**LBS Comments:**

# HANNAH RIDGE at FEATHERGRASS FILING NO. 3

## A RE-PLAT OF TRACT FF, HANNAH RIDGE AT FEATHERGRASS FILING NO. 1, SECTION 32, TOWNSHIP 13 SOUTH, RANGE 65 WEST of the 6th PRINCIPAL MERIDIAN, EL PASO COUNTY, COLORADO

| FINAL PLAT<br>Hannah Ridge at Feathergrass<br>Filing No. 3   |  |

HANNAH RIDGE at FEATHERGRASS FILING NO. 3

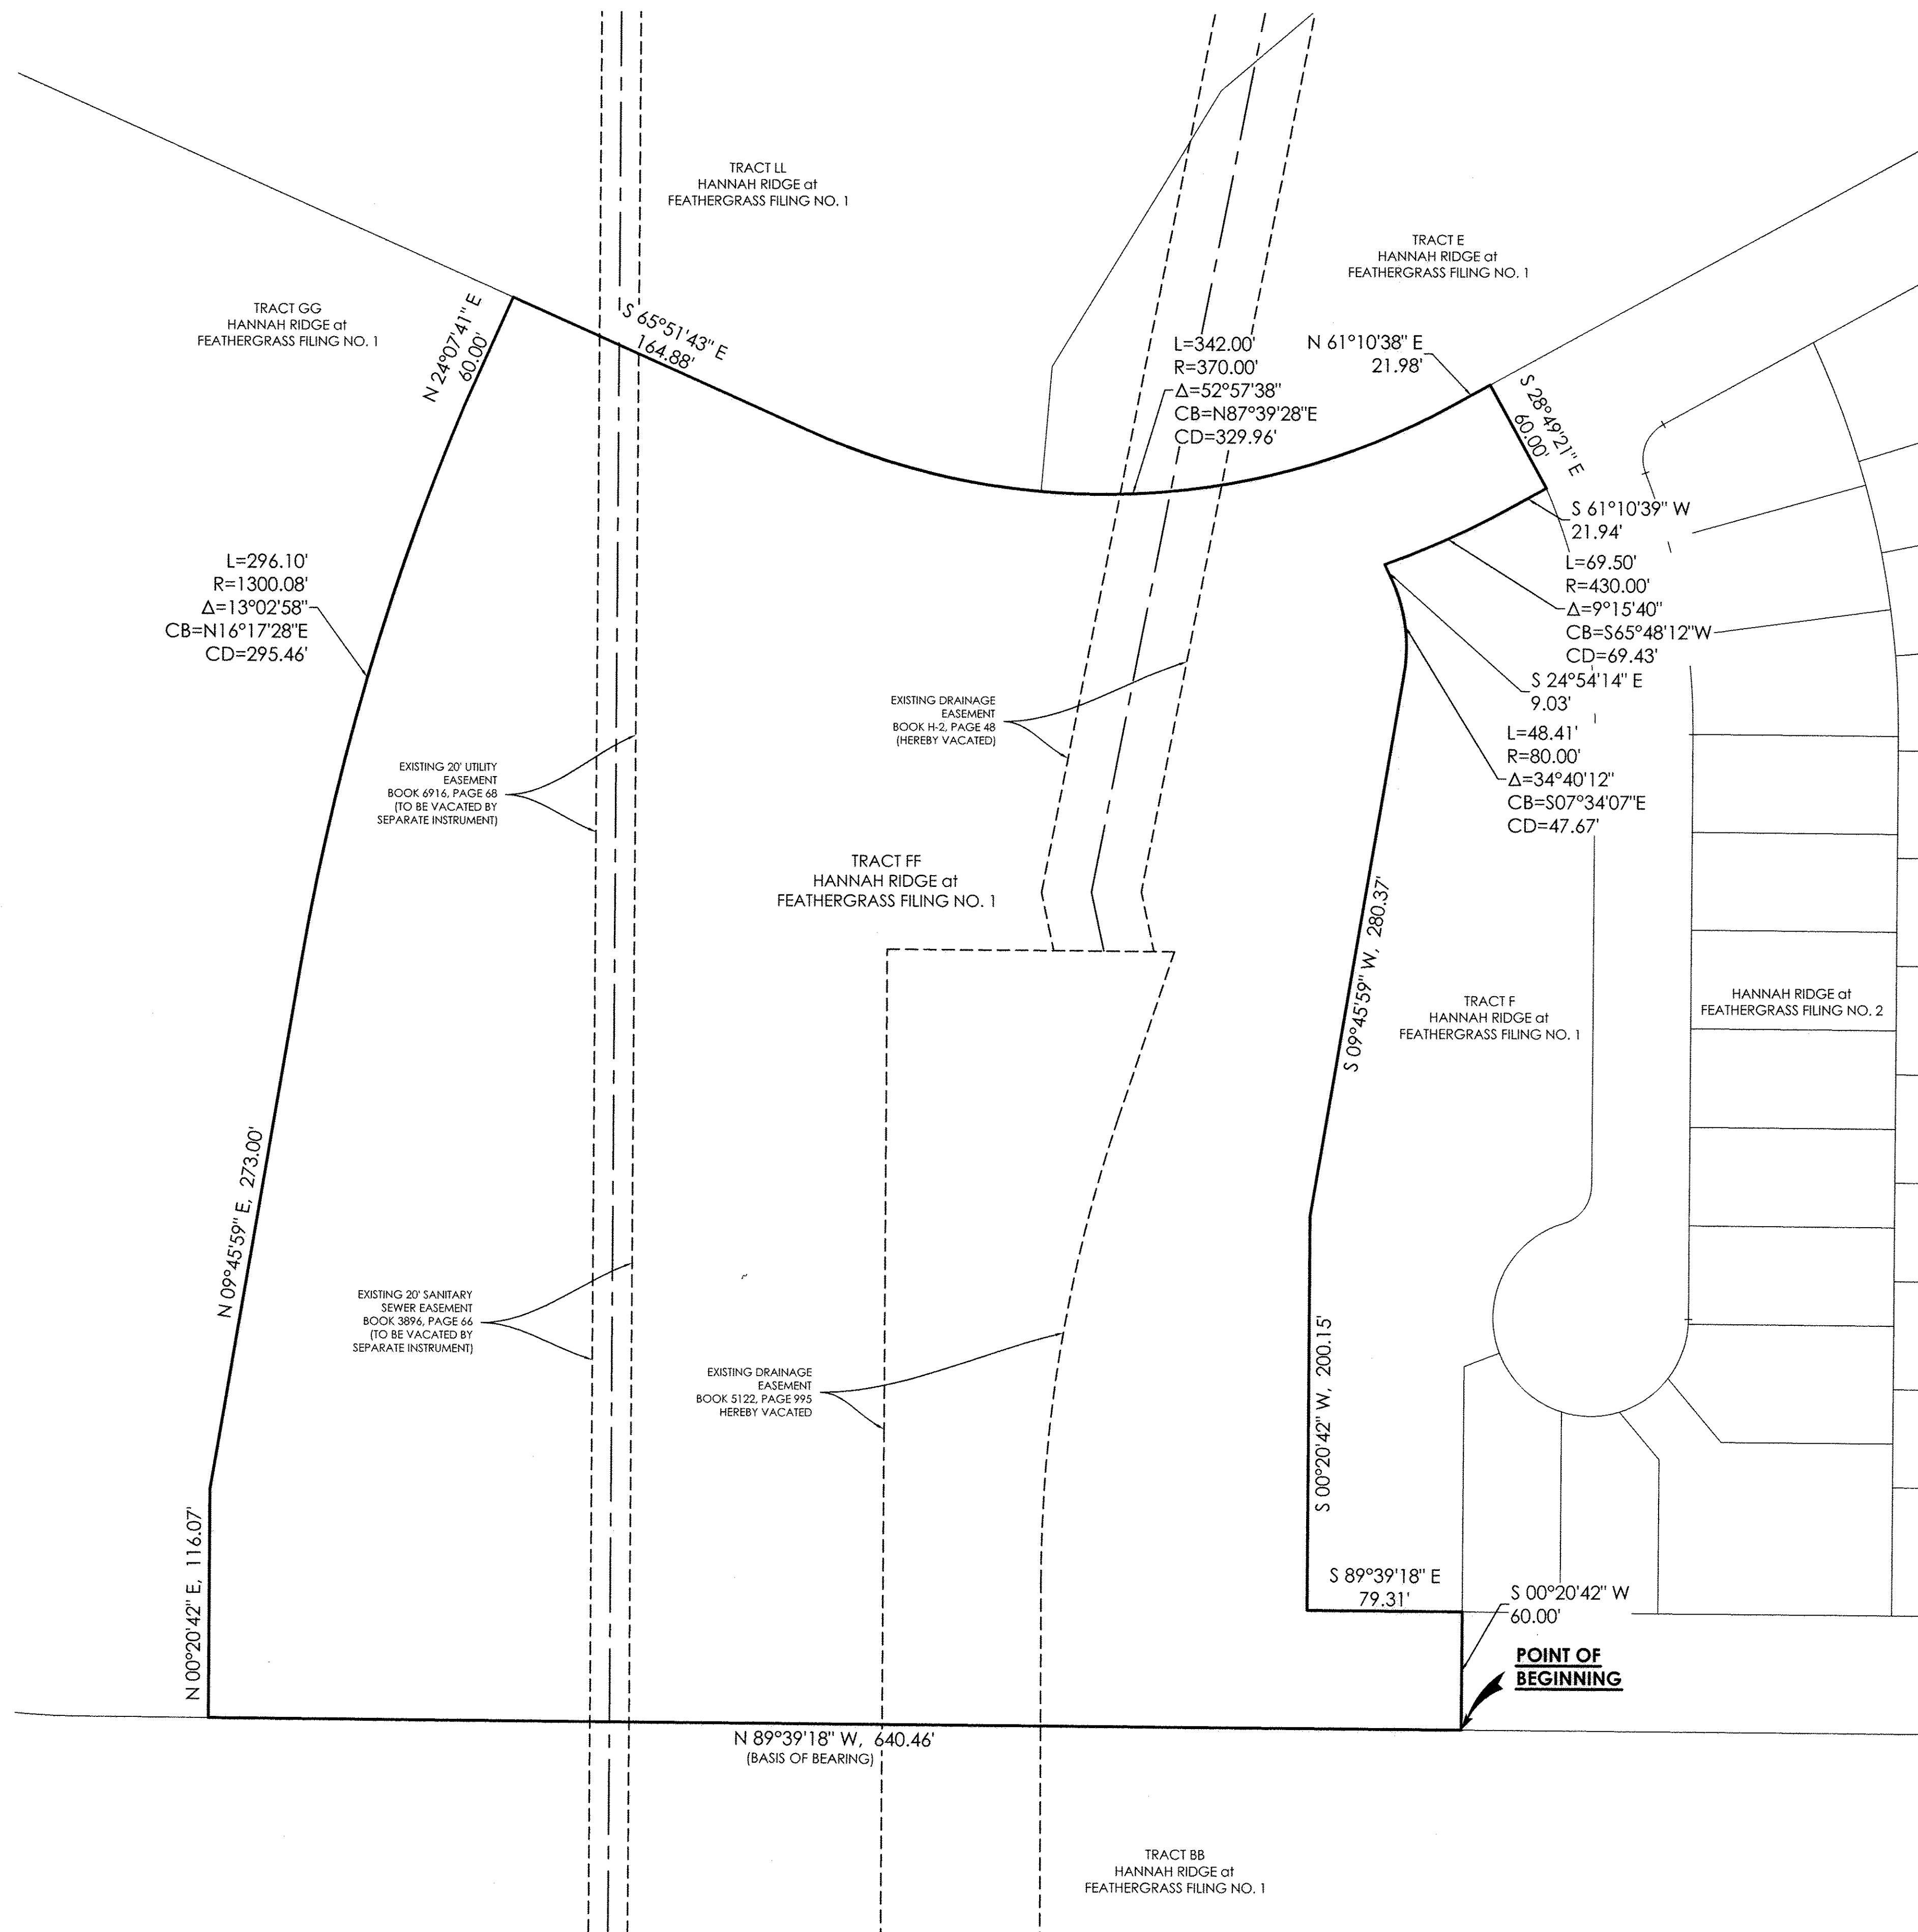
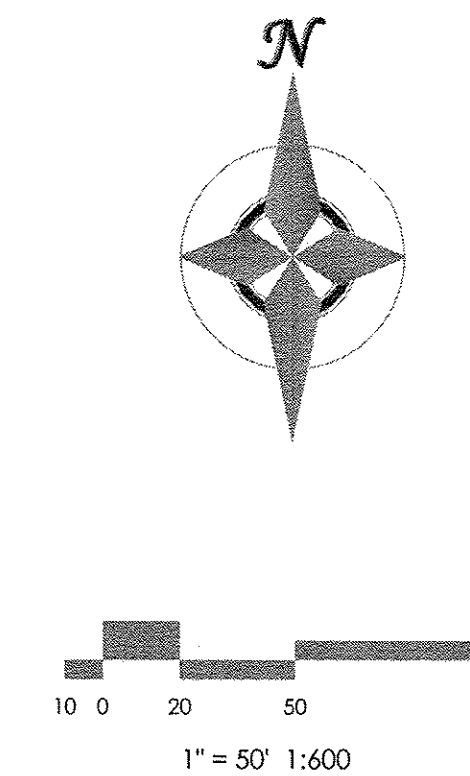
- 1. Please include the monumentation that defines the Basis of Bearing in Note 1.
- 2. Please clear up the overlapping typo along the west line of Lot 1.
- 3. Please label the line that defines the Basis of Bearing on both sheets 2 & 3.

- 4. Change Note 7 to: "All easements that are dedicated hereon for public utility purposes shall be subject to those terms and conditions as specified in the instrument recorded at Reception Number 212112548 of the records of El Paso County, Colorado. All other easements or interests of record affecting any of the platted property depicted hereon shall not be affected and shall remain in full force and effect."

Add the Traffic improvement note "Property within this subdivision is subject to the terms and provisions of the El Paso County Road Impact Fee Program (Resolution 16-454) and any subsequent amendments. Fees for each lot within this subdivision shall be paid in full at the time of building permit issuance. Add that this property is included within the the Central Marksheffel Improvement District

CCRs (Is a park going in this development to replace the one that was not built in Wilshire / Jessica Heights? There was previous discussion about amending the covenants. Detention Pond Maintenance Agreement Place holder notes?
